Re: Proposed windfarm development including 13 no. wind turbines in Bunnyconnellan, Co. Mayo and hydrogen plant in Castleconnor, Co. Sligo.
Carrowleagh, Bunnyconnellan, Co. Mayo and Curraun, Castleconnor, Co. Sligo.

**Chief Executive's Report to the members of Sligo  
County Council on 4 September 2023**

**a Strategic Infrastructure Development (SID)  
application on lands located in Castleconnor, Co Sligo  
(and townlands within in Co. Mayo) submitted to An  
Bord Pleanála on 6 July 2023.**

**The proposed development consists of 13 no. wind  
turbines in Bunnyconnellan, Co Mayo and a Hydrogen  
plant within Castleconnor, Co Sligo**

Figure 12.105: Hydrogen Plant Digital Surface Model ZTV Map indicating parts of the Study Area with potential views of the proposed Hydrogen Plant taking account of vegetation screening

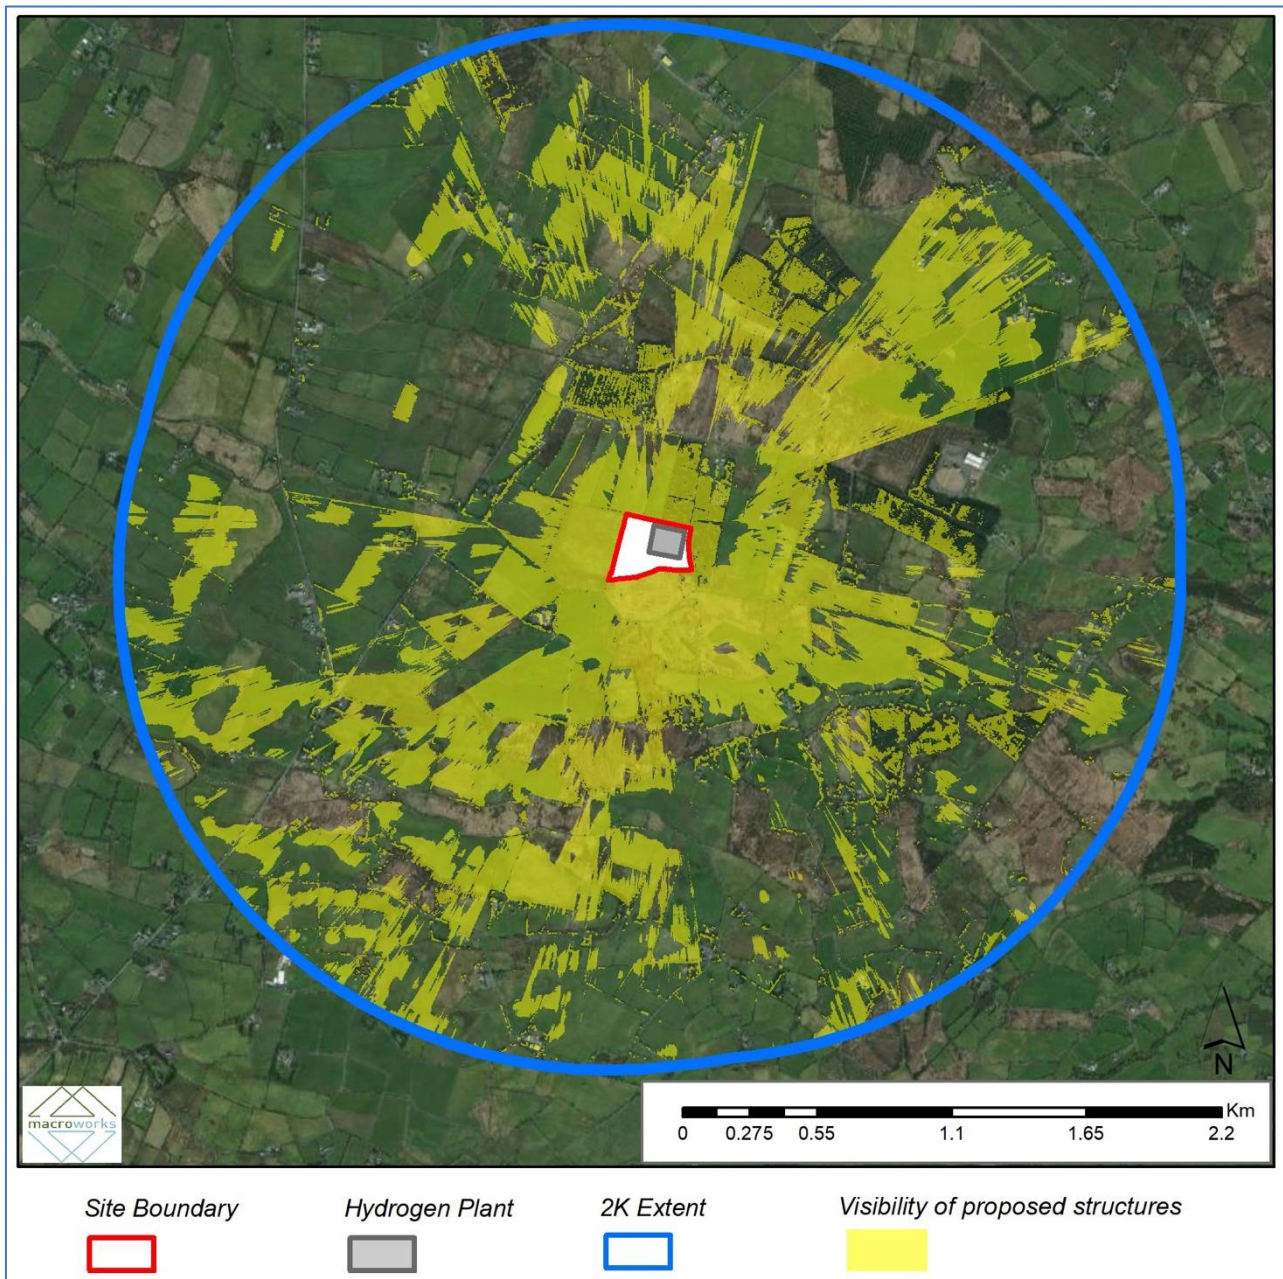
The application includes, as part of the EIAR, a Landscape and Visual Impact Assessment. The core focus of this is the impact of the wind energy development within Co. Mayo however it does also include an assessment of the visual impact of the hydrogen plant / electrolyser building. This includes an assessment of the zone of theoretical visibility (ZTV) and a wireframe viewpoint assessment (from four points) within a 2km range (ZTV - based on a model of the development and topography of surroundings indicates locations where development will be visible as a worse-case scenario; Viewpoint Assessment - this is a process where photographs from the surrounding areas are compared with and without the development, and based on a 3D outline model of the development).

The assessment outlines that the main unobstructed views of the hydrogen plant will be from unpopulated private land predominantly in agricultural and forestry use. Beyond that, and from the nearest public roads and residential buildings, and due to the landform surrounding the site, the views would be more sporadic and mainly of the upper profile of the electrolyser building only. There would be brief visibility from a section of the N59. The alterations to the N59 junction will be a much more intensive form of road infrastructure (when compared to the existing) and which would completely change the nature of the road (from a rural access/road). The assessment notes that beyond 1km the building would not have a notable impact on the landscape. The wireframe viewpoint assessment does include for additional landscaping (hedges etc) to mitigate in some way any visual impact. Given the separation of the proposed wind farm (and existing wind energy development) from the hydrogen plant site there would be limited cumulative impact on the rural landscape.

In conclusion, it is considered that while the proposed hydrogen plant would have a visual impact on the rural landscape given its scale and nature (as an untypical addition to a rural setting) due to the topography of the site and surrounding area any impact would likely be of a localised nature only. However, it is noted that within the submission there is limited information contained on the design detail and visual appearance of the hydrogen plant / electrolyser building to demonstrate the design quality and appropriateness of the appearance of the building, given its scale, to this rural setting (e.g. CGI images, design statement, site sections, evidence of consideration of detailed siting, materiality). The submitted information is limited to basic elevation and plan detail only. While it is understood that the development would likely be of a utilitarian appearance a more detailed examination of the site context and further understanding of the requirements of the building may have led to a more informed design or siting and possible reduction in the scale of the building and therefore visual impact of the development. The careful consideration of this matter by ABP is recommended.

Figure 15.13: Junction Turning Movements at N59 / L-6612-1 – AM Period

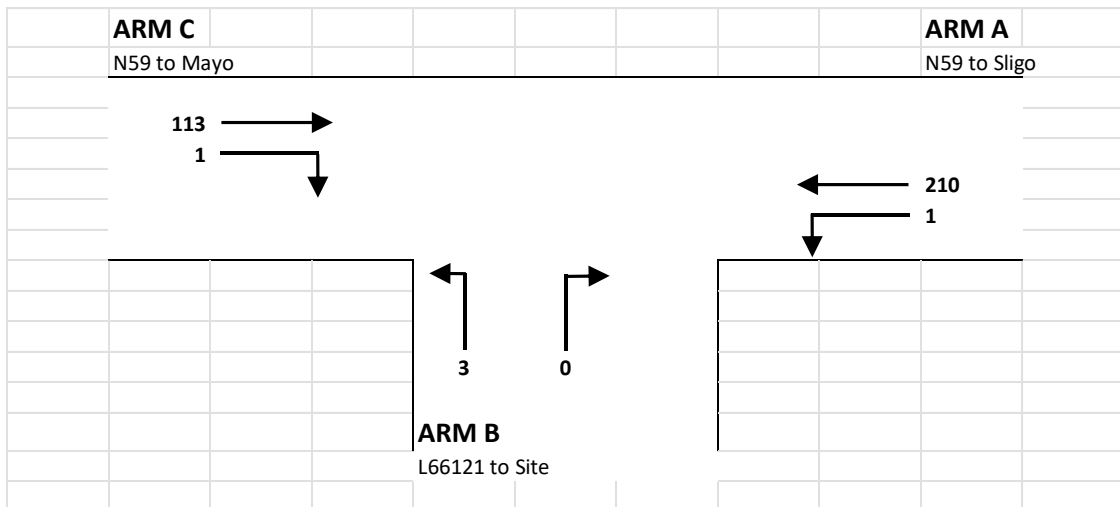
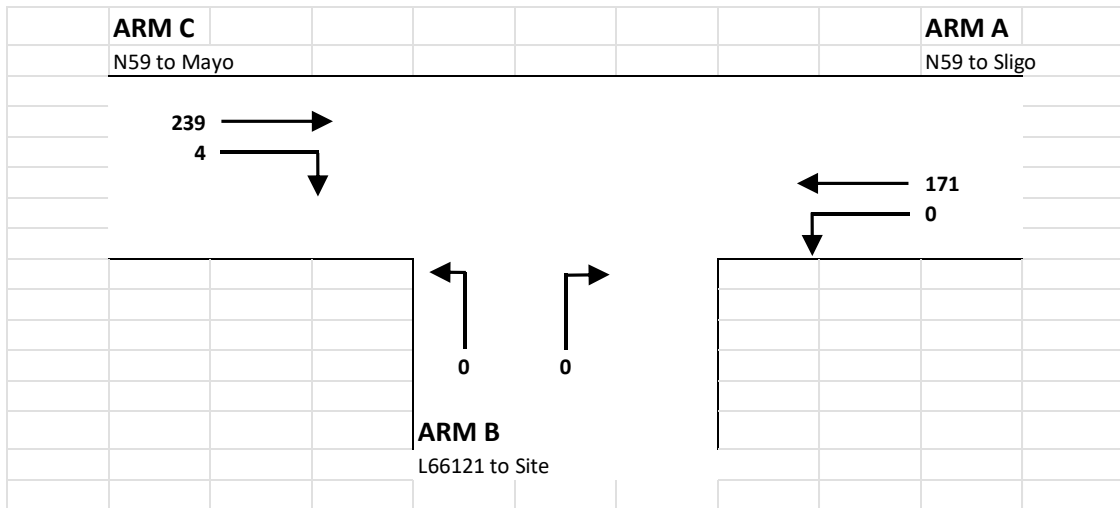
The main on-going transport impact from the development would therefore be the requirement of the local and national transport network to accommodate the 'tube-trailers' (HGVs) for the hydrogen plant and traffic for workers at the hydrogen plant. The assessment identified that there would be a maximum of 26 tube trailers filled with gaseous hydrogen transported away from the plant everyday (therefore 52 total movements), and approximately 10 cars attending the site for workers. The assessment states that post-reconfiguration of the N59 junction, this would represent just 5.9% of the capacity of this junction. As such the conclusion of the assessment is that traffic generated would be imperceptible due to the type of traffic and the low volume of traffic generated during operation. It is noted that the assessment includes a Road Safety Audit however it is considered this does not appear to fully address the implications of the safety of the new junction to the N59 and instead focuses on the design of the roundabout access. Furthermore, it is unclear if the

applicant has adequate control from adjoining landowners to maintain the sightlines at this new junction. These matters should be fully considered by ABP.
